CITY OF ALBUQUERQUE

**RE: Partial Pond Recovery and Relocation, 6500 Alameda Blvd. NE
Grading Plan For Grading Permit
Engineer's Stamp Date 4-23-2014 (File: C18D079)**

Based upon the information provided in your submittal received 4-23-14, the above referenced plan is approved for Grading Permit with the following comments:

COVER PAGE

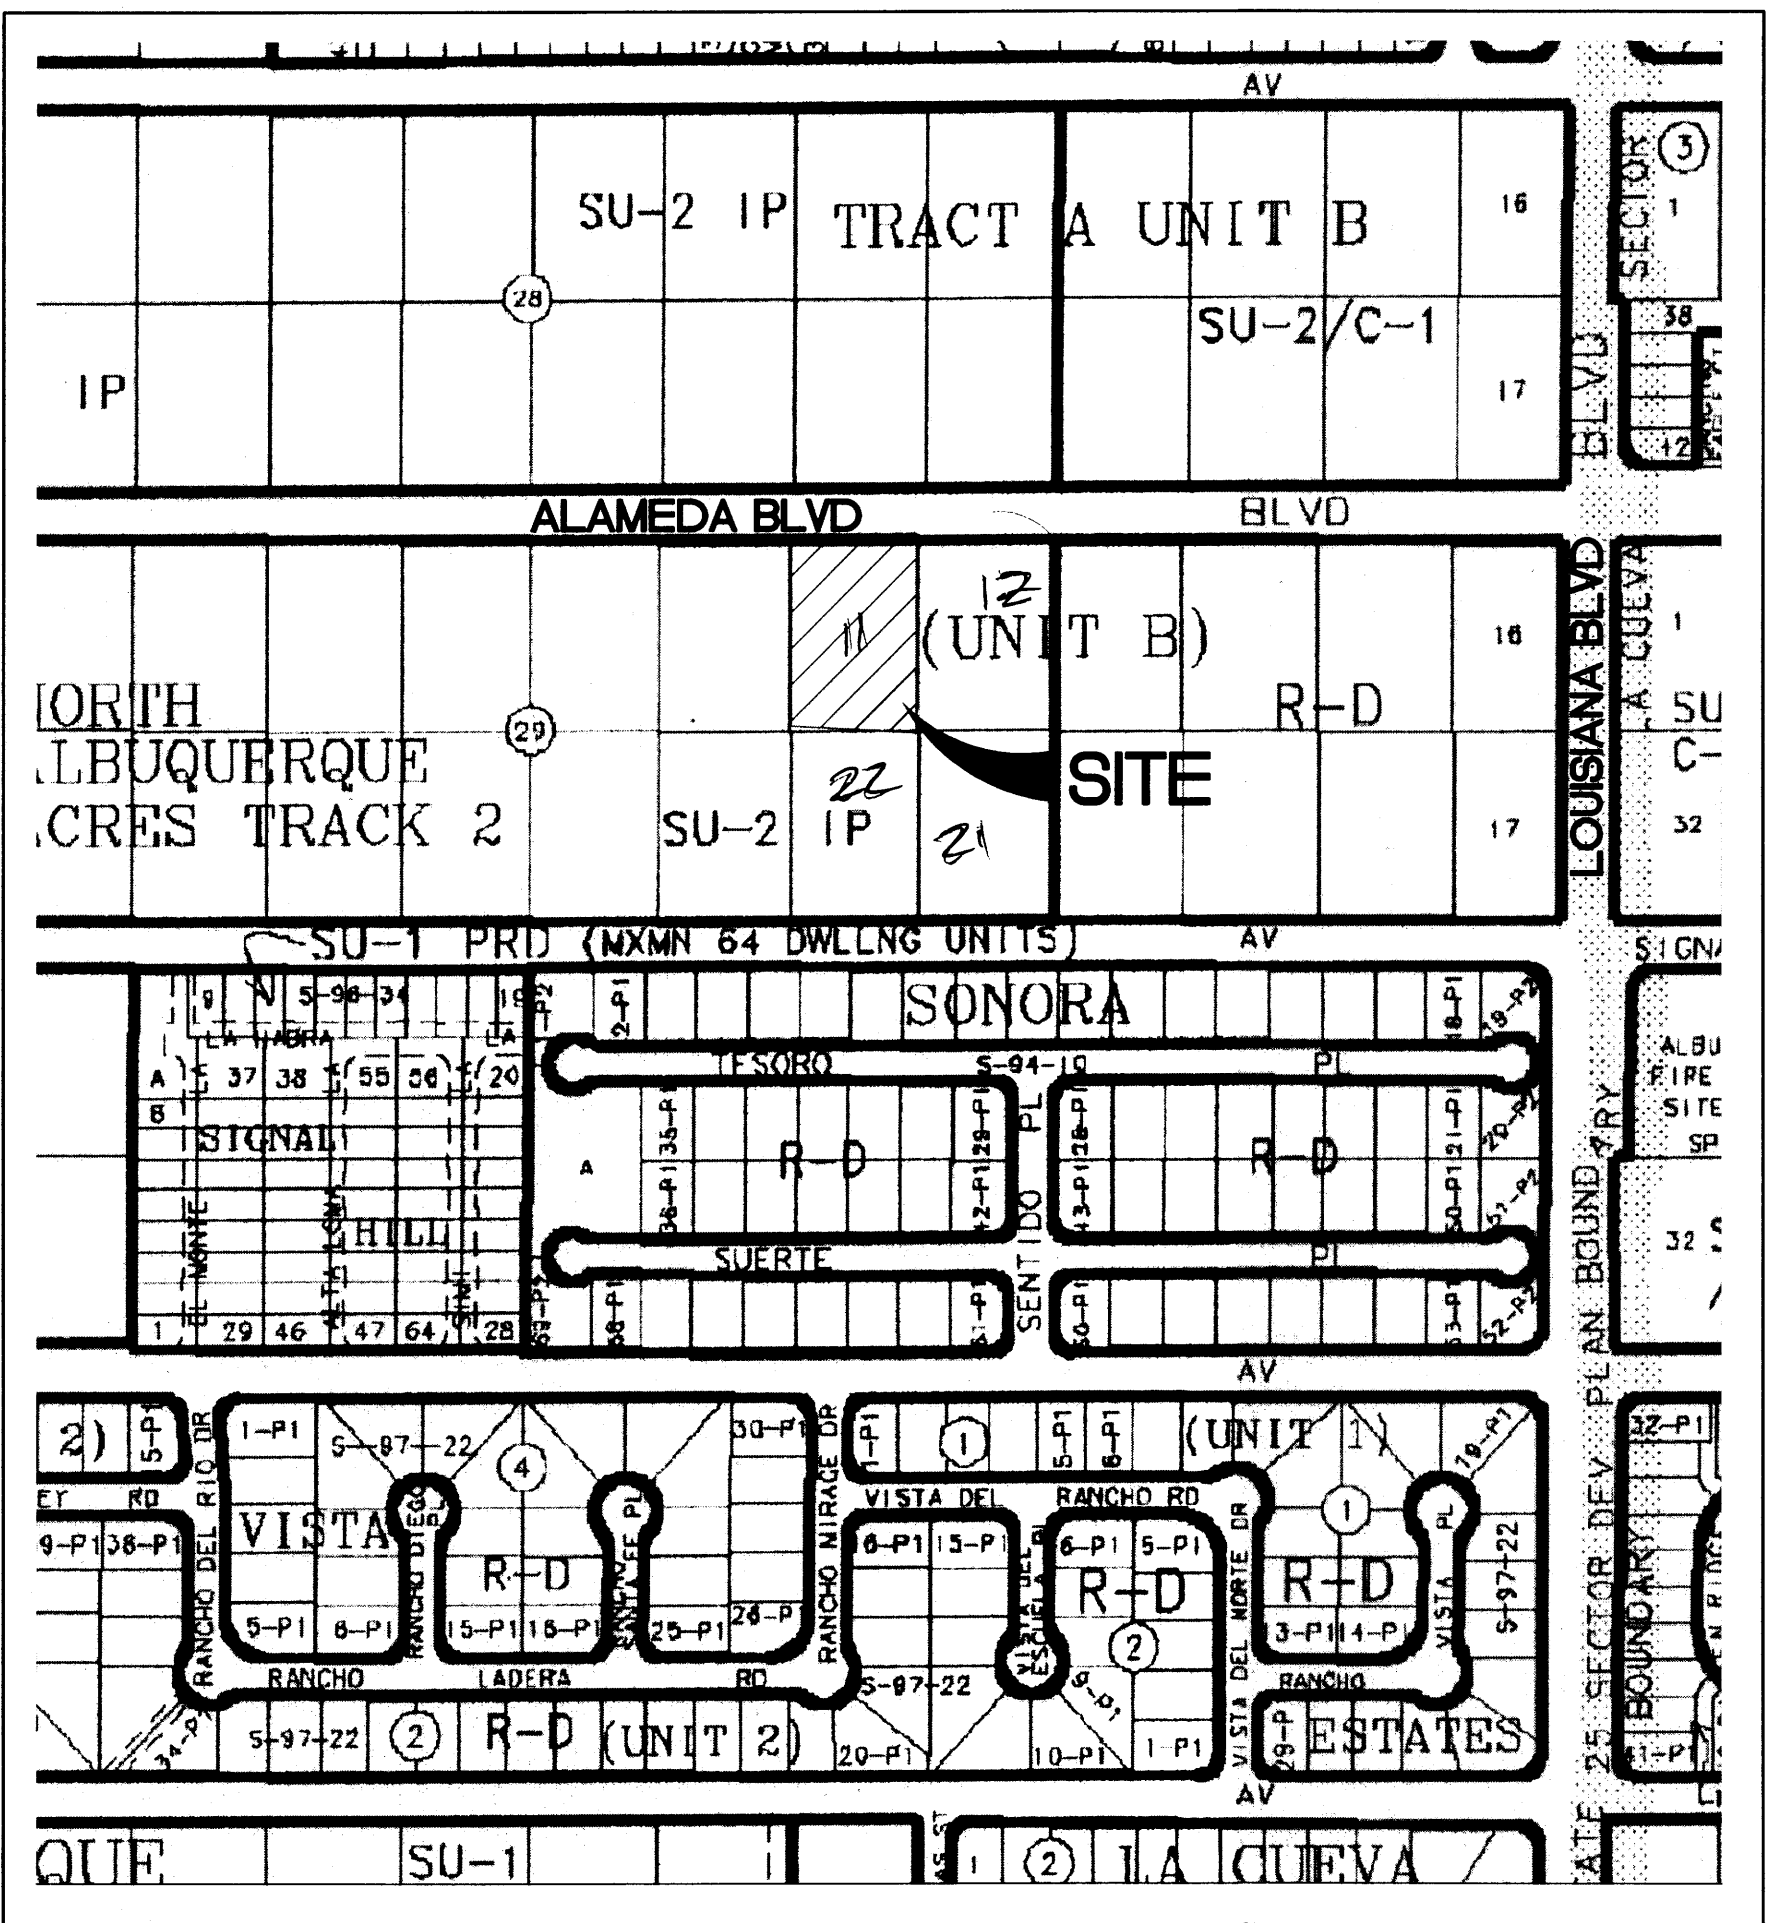
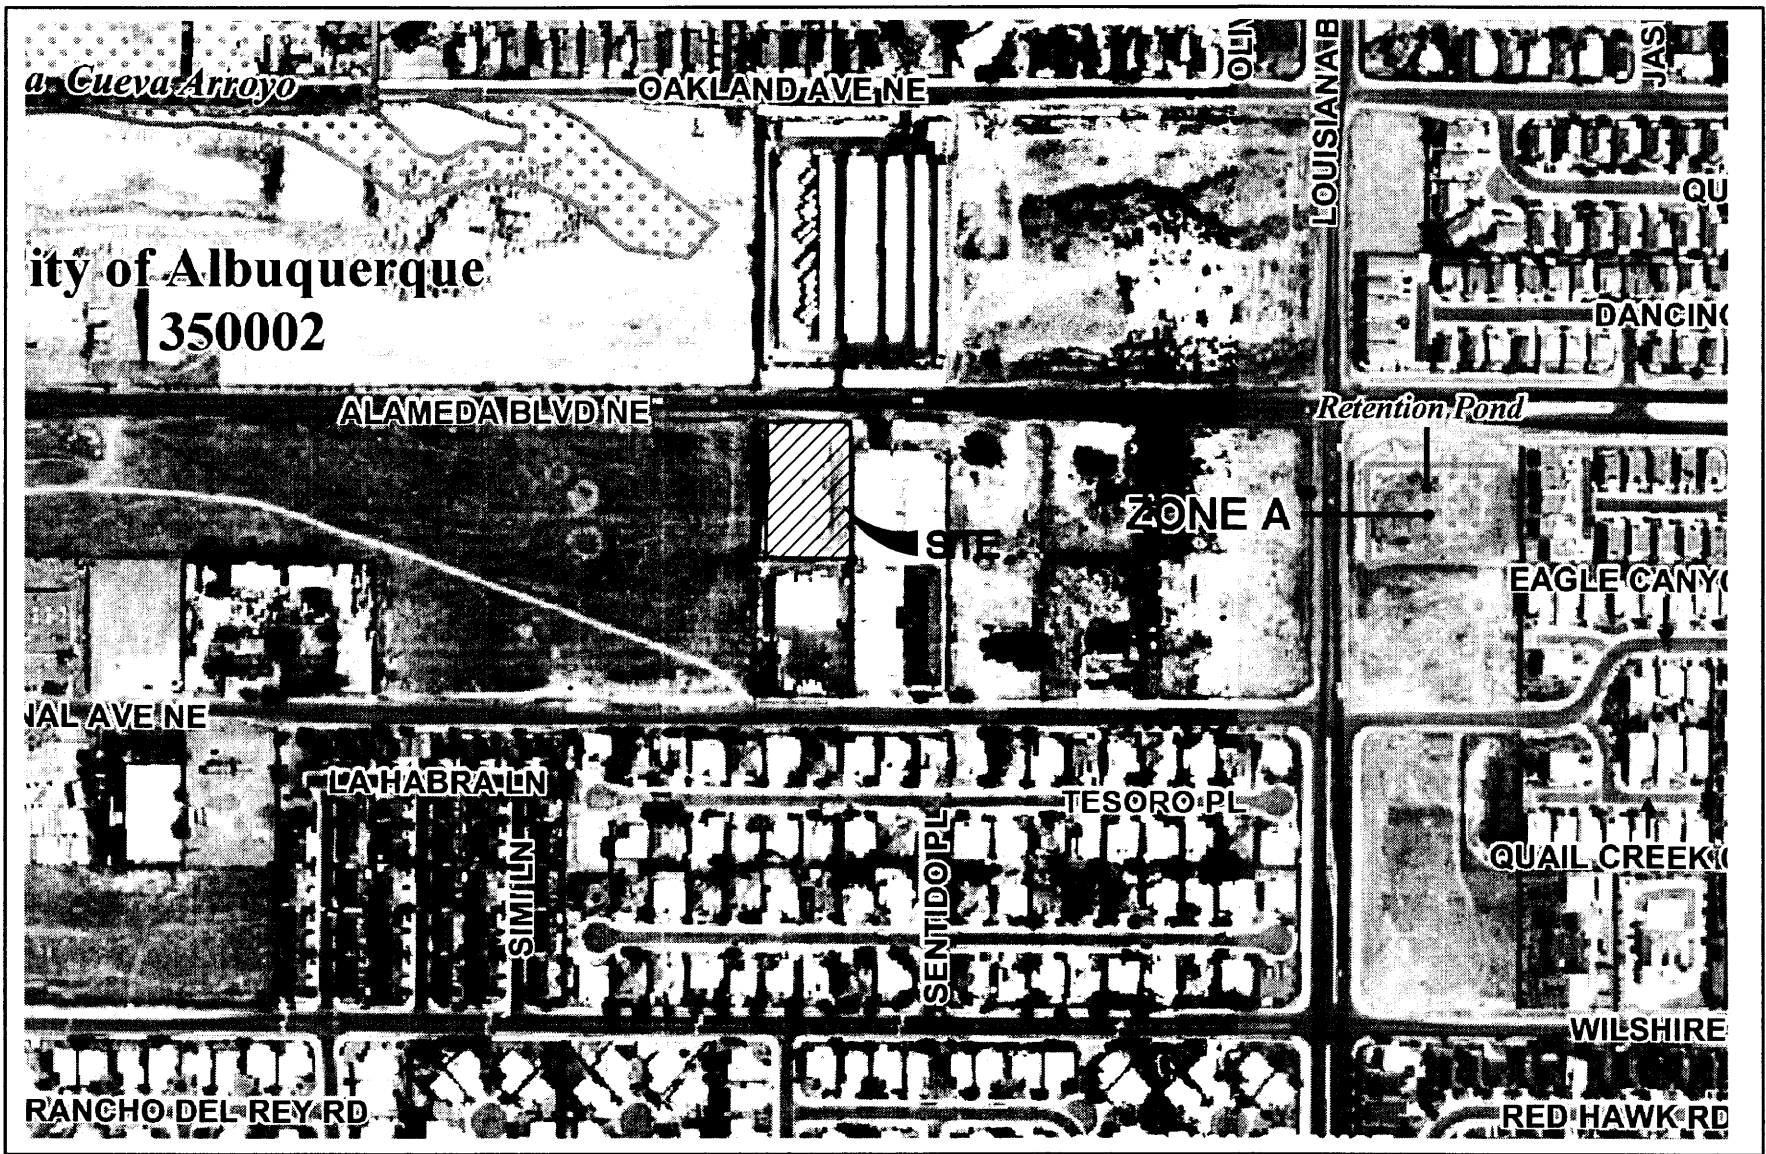
- On the title sheet, correct the Existing Conditions narrative as it is partially unreadable.
- On the title sheet, correct the Developed Condition narrative to state that pond is to contain flows from Lot 11 only.
- Also, it would be helpful to include the Lot No.'s in the Vicinity Map referenced in the narratives.
